Subject: Planning Comment (Objection) Re: FG/14/22/PL 9 Ocean Parade Ferringham Lane Ferring BN12 5QG

Application FG/14/22/PL follows a submission for prior approval for change of use of commercial (retail) units to residential (FG/206/21/PD).

This current application to "Replace existing shop front to ground floor front elevation with new door and windows....." makes no reference to the intended future purpose of the site which it refers to as 'retail'.

Drawing
Proposed Elevations.

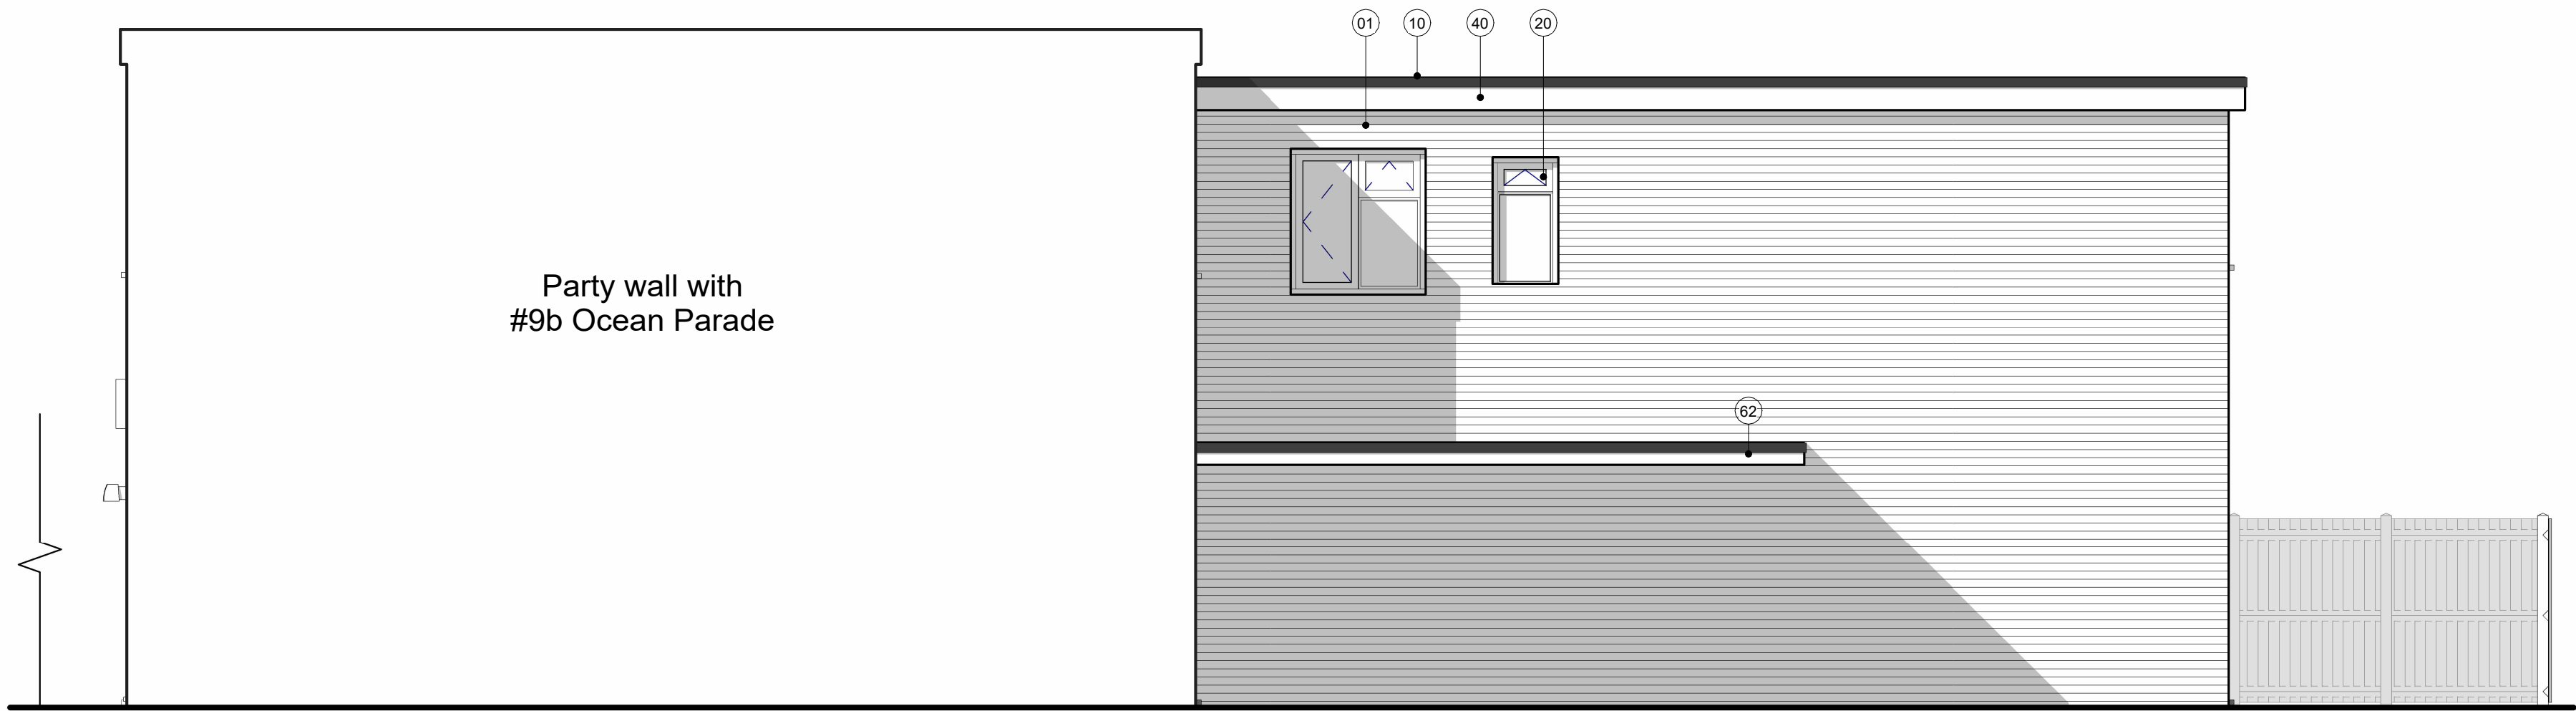
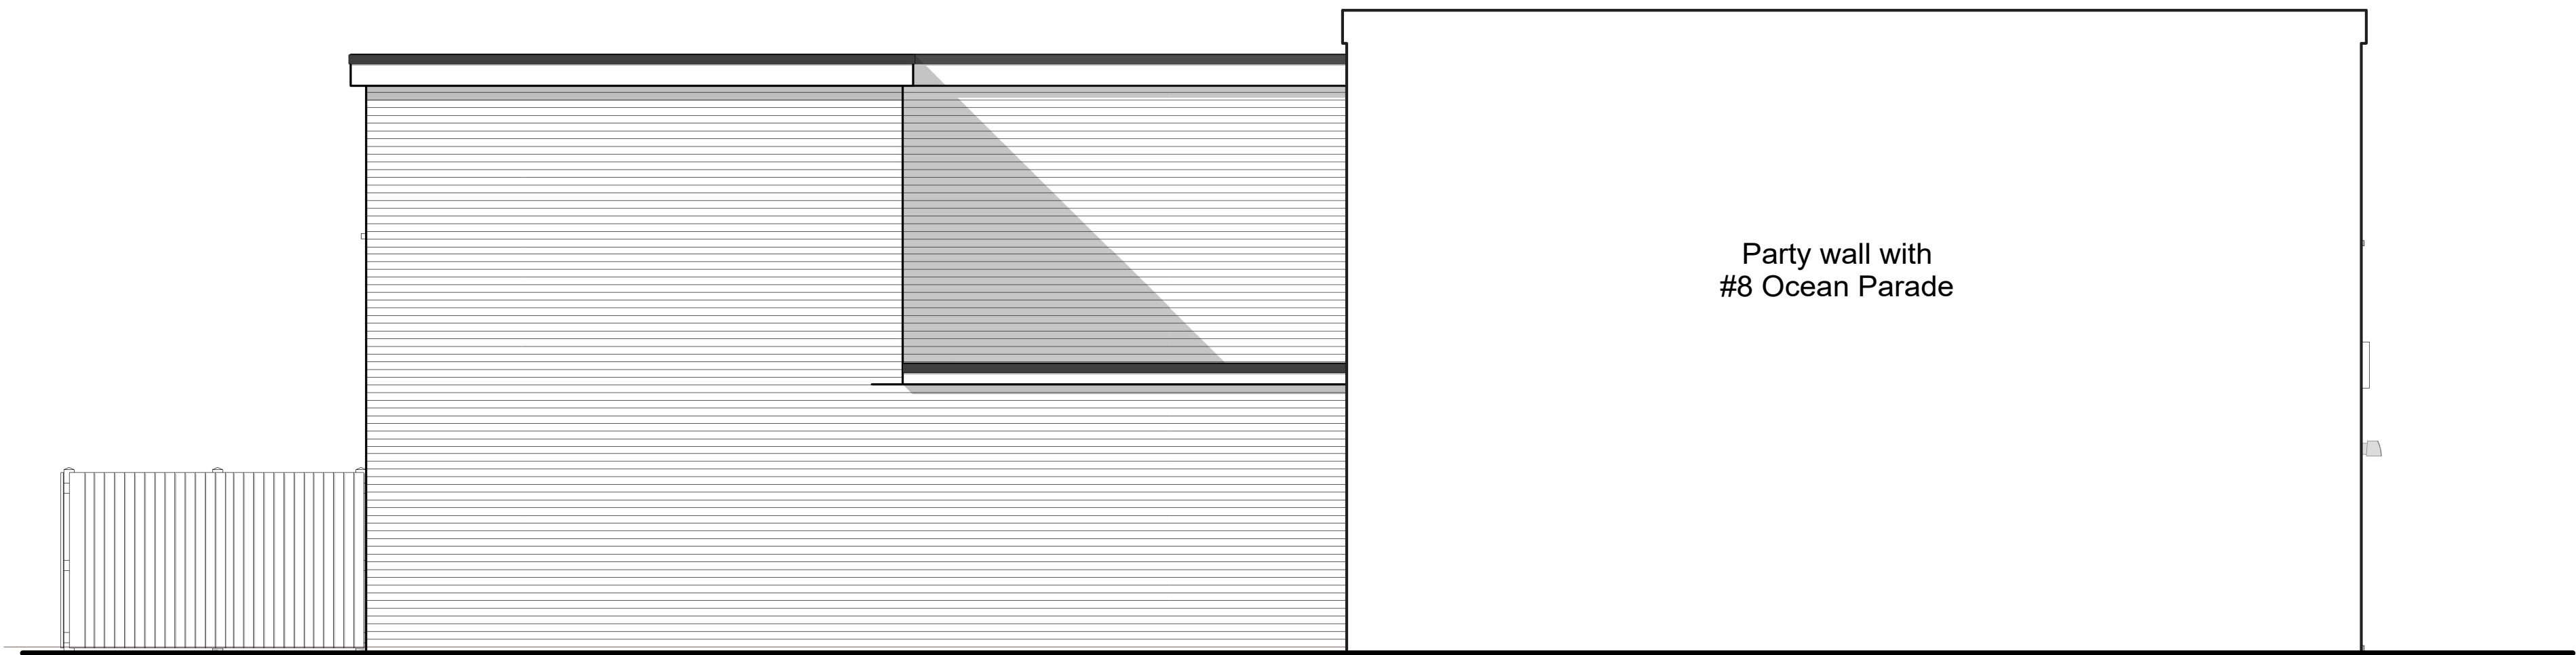
In isolation, there is no rationale for the design in this application. The proposed exterior design would not be in keeping with retail units and no floor plans for sub divided retail have been provided. The Parish Council would therefore object on the basis that the proposed redesign is not commensurate with its ongoing retail use and is out of keeping with other units in the immediate area.

In summary, Ferring Parish Council objects to this application (FG/14/22/PL) as it would be unsympathetic / unsuitable for continued retail use, out of keeping and failing to provide corresponding interior design detail.

Officers should be satisfied that any external changes are suitable for the site's continued retail use to maintain the ongoing viability and identity of this village centre and in keeping with other retail units in the locality.
